Application Ref:	2026/0626			 Ribble Valley Borough Council www.ribblevalley.gov.uk	
Date Inspected:	N/A	Site Notice:	N/A		
Officer:	EP				
DELEGATED ITEM FILE REPORT:				Decision	PRIOR APPROVAL REFUSED

Development Description:	Prior notification for a proposed earth banked slurry lagoon to store cattle slurry to be utilised on the farm, under Part 6 Schedule 2 of the GDPO.
Site Address/Location:	Foulds House Farm Sabden Road Simonstone BB12 9AD

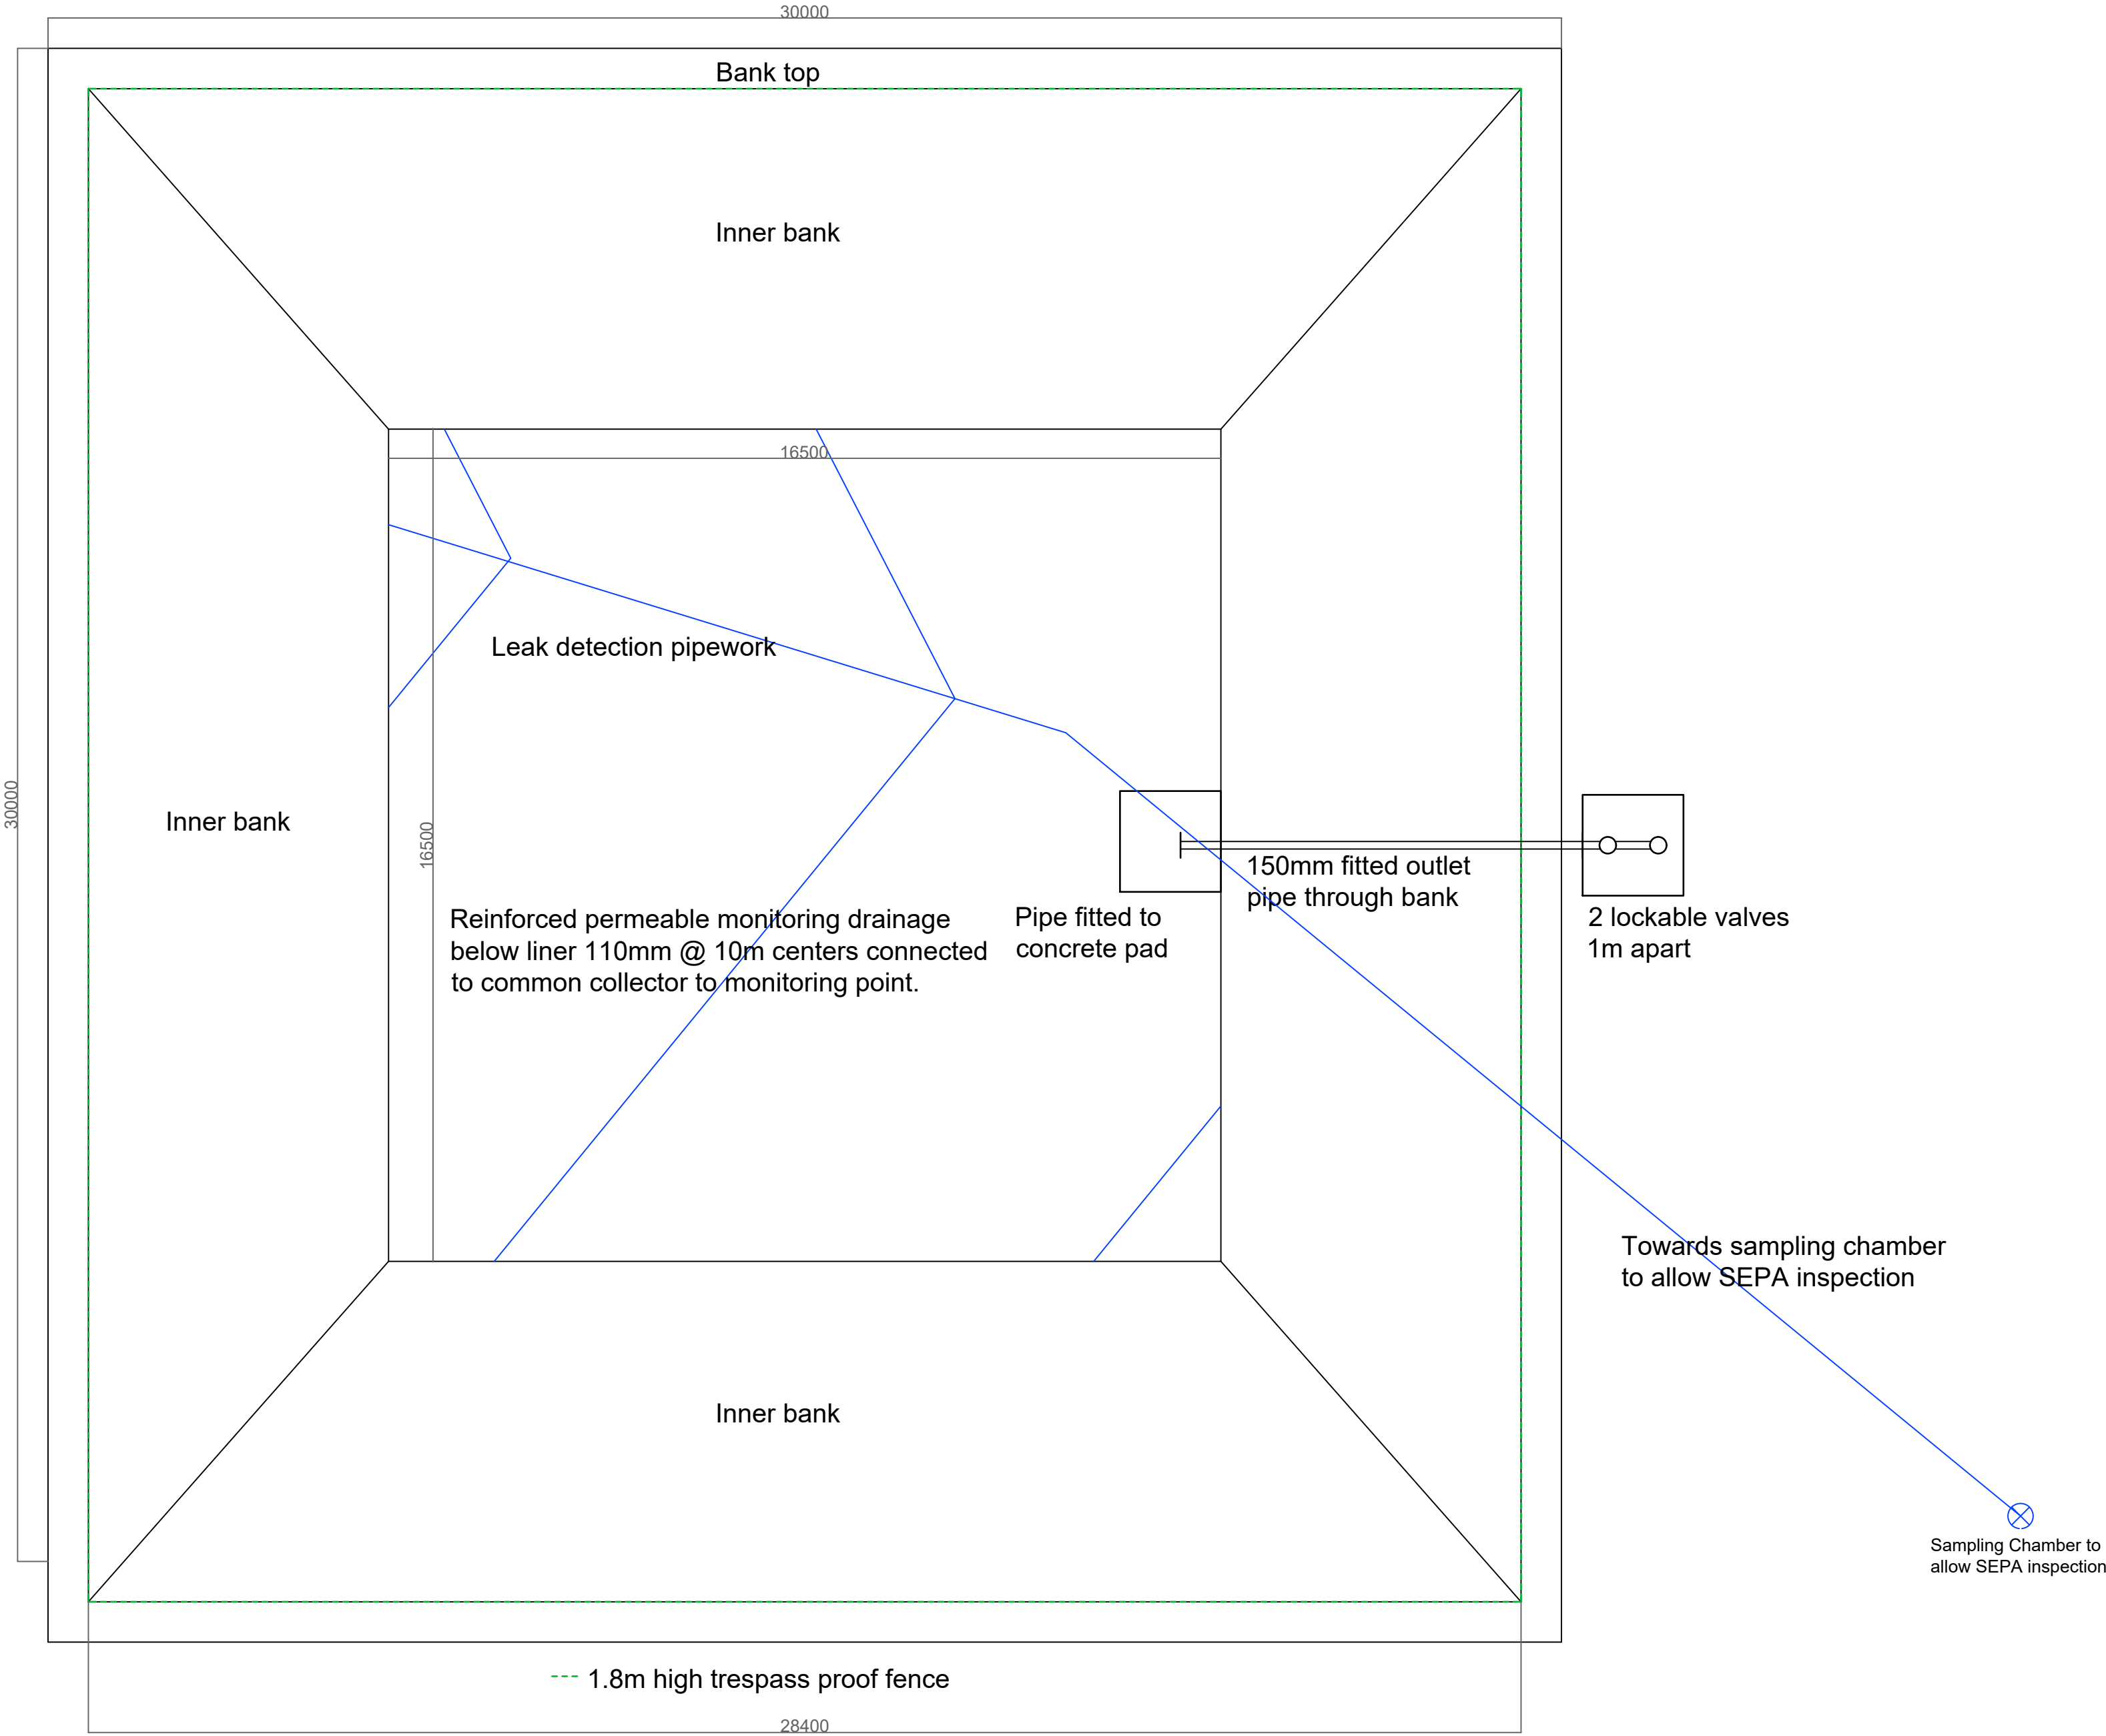
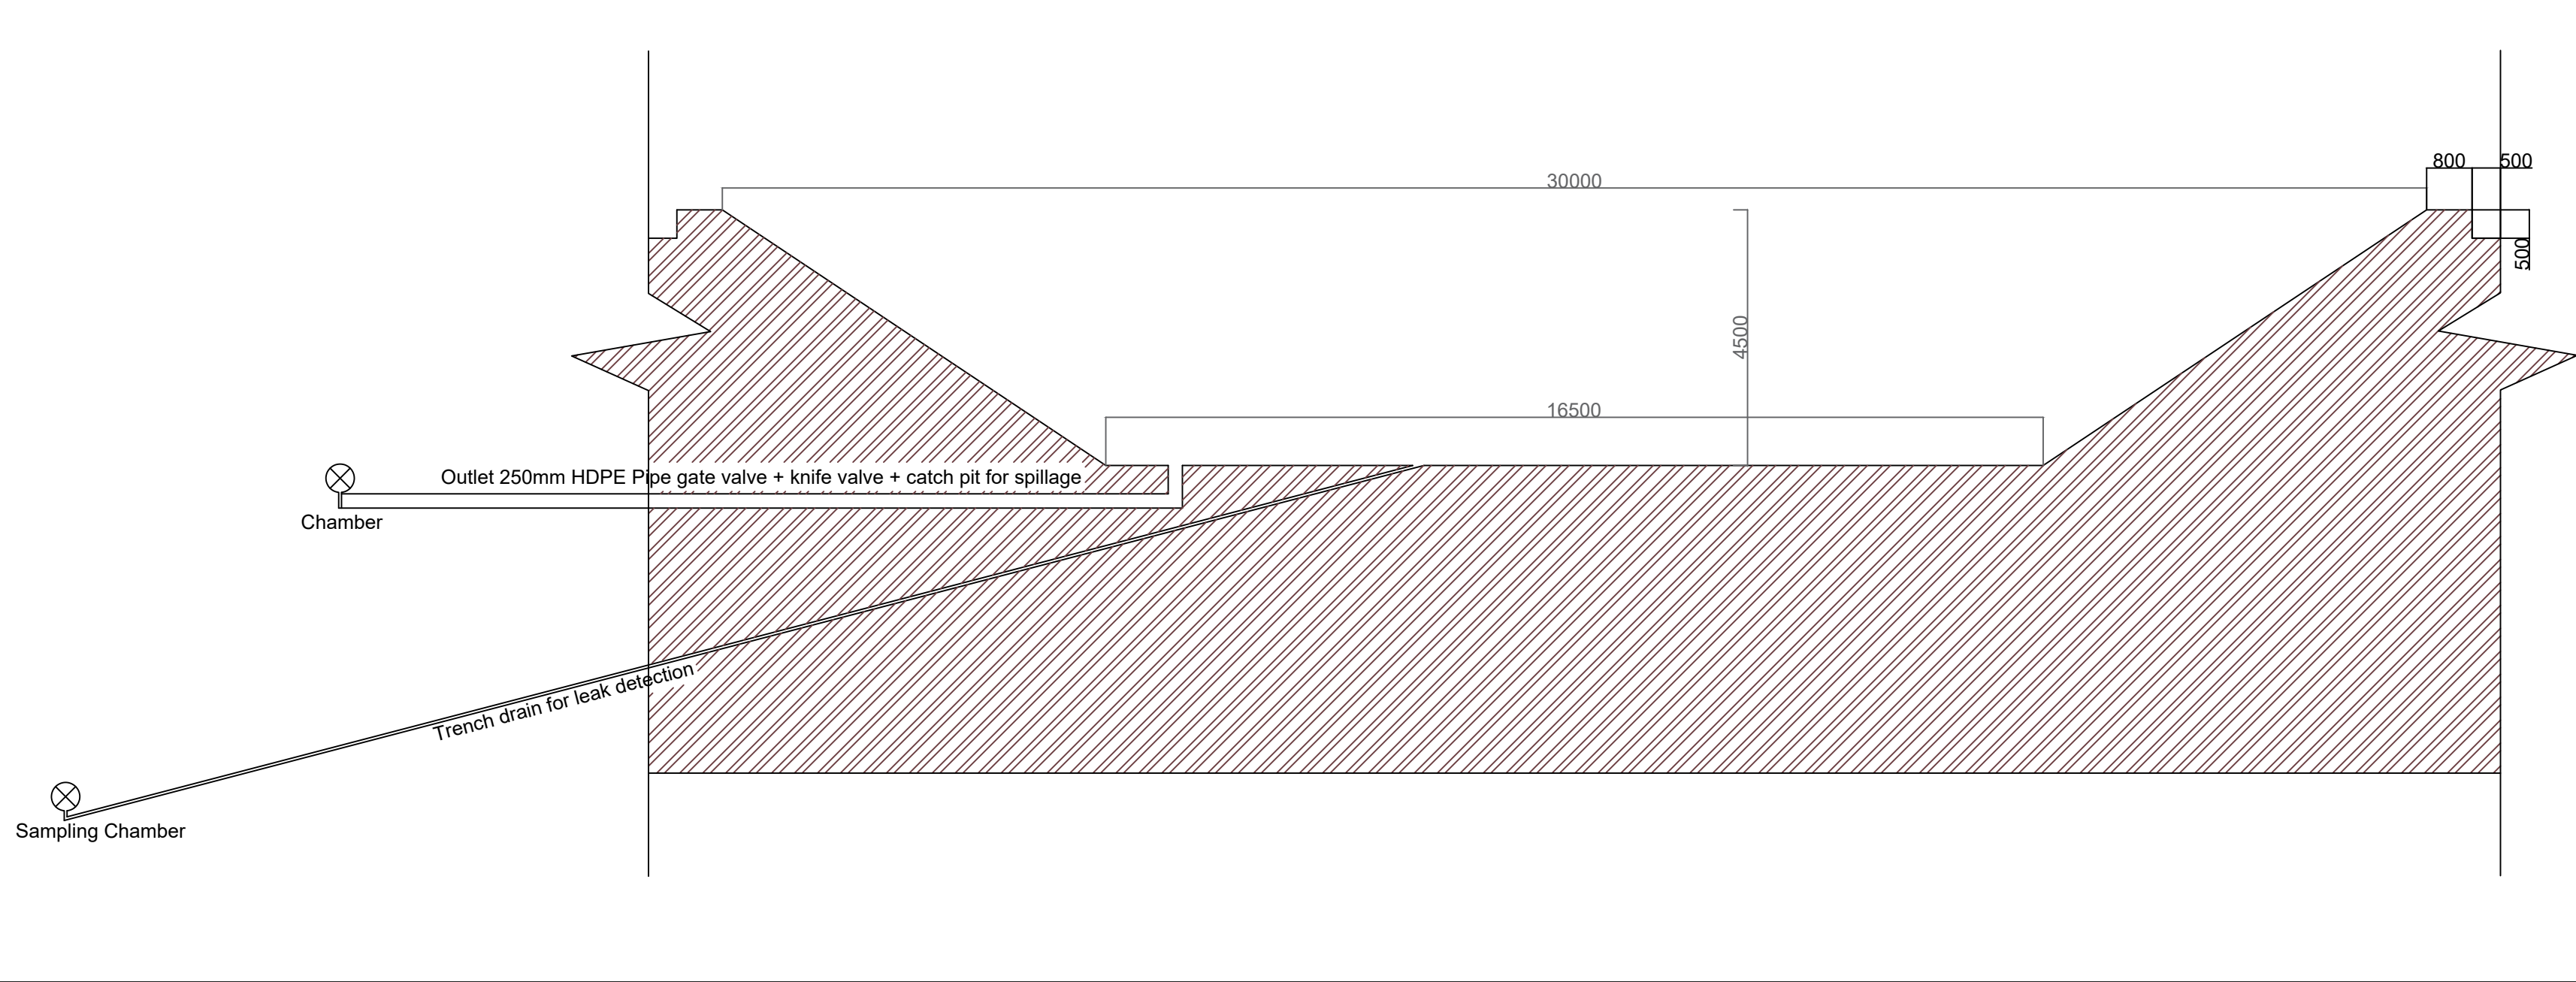
The proposed slurry lagoon would measure 0.5 above ground level with a 1.8m high perimeter fence.

The proposed slurry lagoon is located a substantial distance from the main farmstead in an isolated position within an undeveloped land parcel. Whilst the proposed lagoon has a relatively modest height of 500mm, the surrounding perimeter fence has a height of 1.8m. The introduction of development of this nature within an undeveloped land parcel would be considered harmful to the character and openness of the open countryside. No justification for the proposed development being in such an isolated position has been provided

The proposed slurry lagoon is designed in a way that is typical for an agricultural holding of this nature, being earth banked and largely undetectable. However, the proposed surrounding perimeter fence is not typical and would increase the visual prominence of the development. The perimeter fence is likely to look overly domestic in appearance and being 1.8m tall but covering a relatively small floor area would appear anomalous within this isolated setting.
